CITY OF ALBUQUERQUE

**Re: DaVinci's Restaurant, 2904 Indian School Rd. NE,
Traffic Circulation Layout
Architect's Stamp dated /missing (J16-D005)**

Based upon the information provided in your submittal received 03-11-13, the above referenced plan cannot be approved for Building Permit until the following comments are addressed:

TCL PLAN

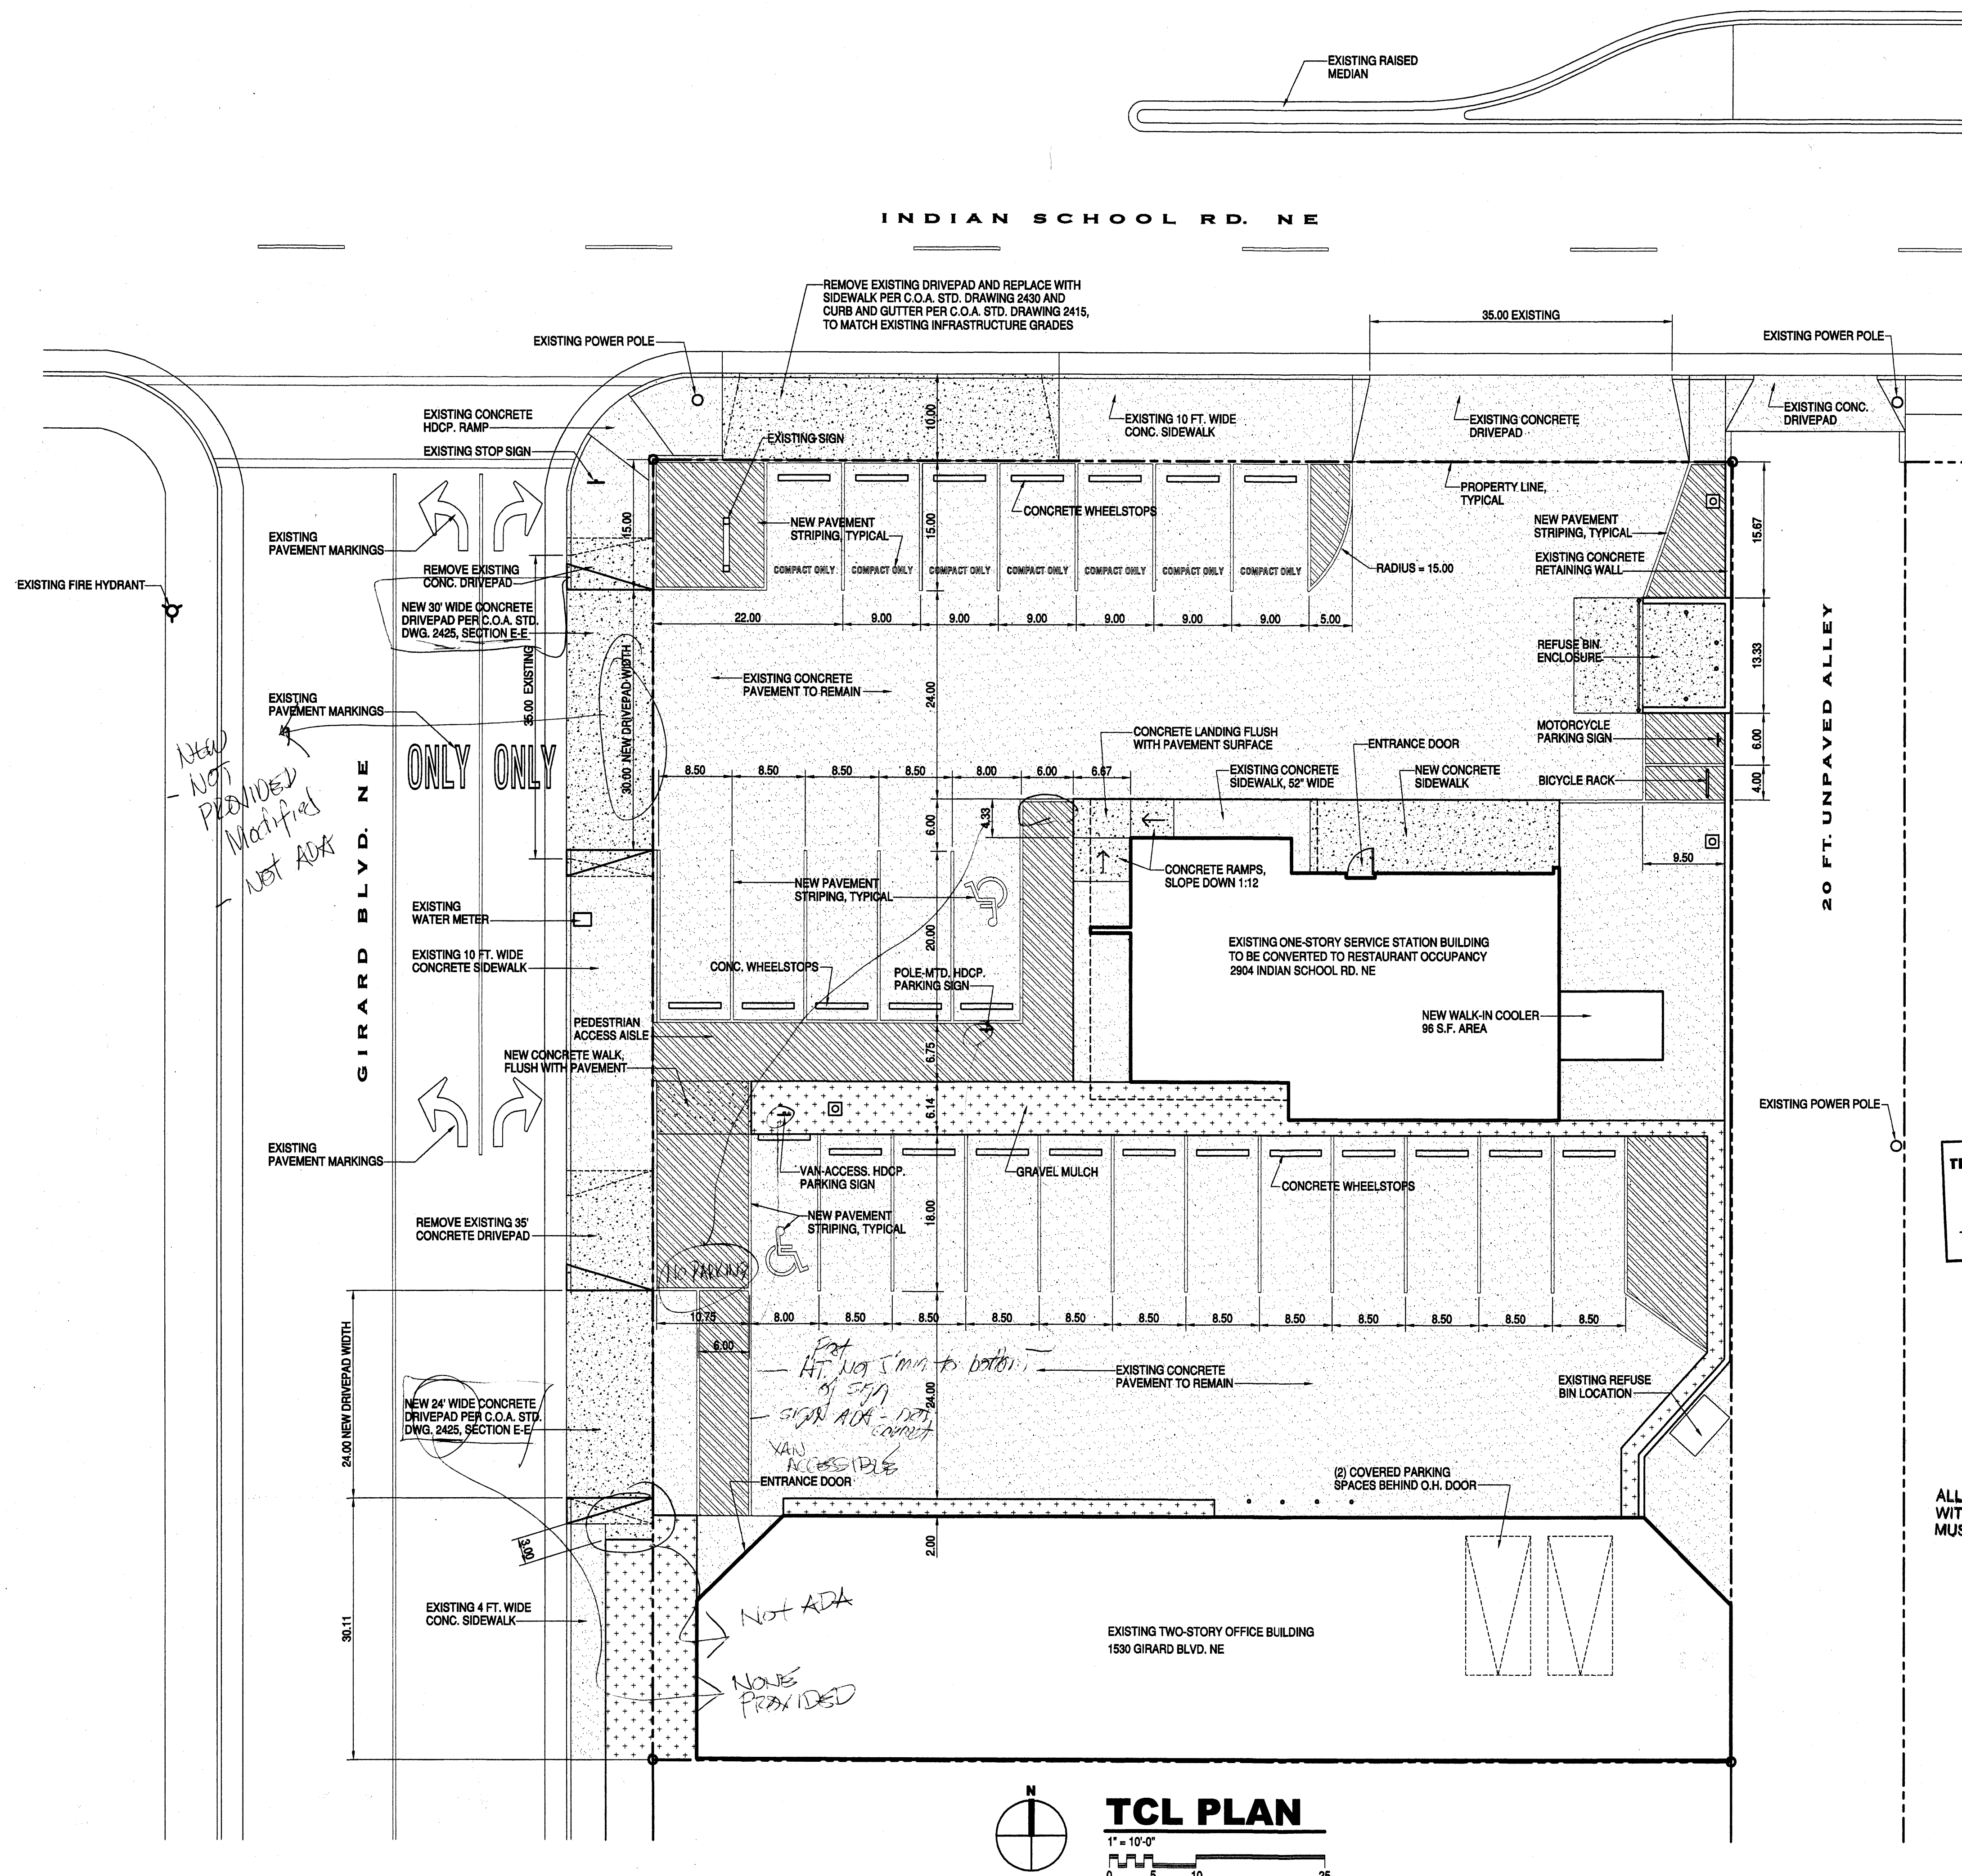
2. Site plan indicates a "new curb ramp" adjacent to the ADA parking access aisle however details have not been provided. The ramp must comply with current ADA standards. Please provide details, including width and length of proposed ramp as well as the dimensions of landing at the top of ramp.

3. The existing sidewalk approach to the restaurant entrance is "52 inches wide". A variance must be requested for this width reduction or the site plan must comply with current standards. DPM requires 6 foot ADA accessible paths, providing the shortest accessible route, from both the ADA parking and public sidewalk to the entrance of public establishments.

4. The C.O.A. STD. DWG # is missing from the site note for the new 30' concrete drive pad. Please provide. Suggest using DWG # 2425, sec. E-E, providing a minimum 3 foot ADA compliant sidewalk at the property line.

5. The southern curb cut on Girard must be reduced to guide incoming vehicles into the access aisle and not into parked vehicles. There is a double yellow line prohibiting left turn access into this parking lot entrance. Also, Girard is classified as a collector; therefore a drive pad of 25-30 feet is permitted according to the DPM Ch. 23 Sec 6, B.9.a.

6. Please ensure all ramps are ADA compliant.
7. Please refer to all applicable city standards
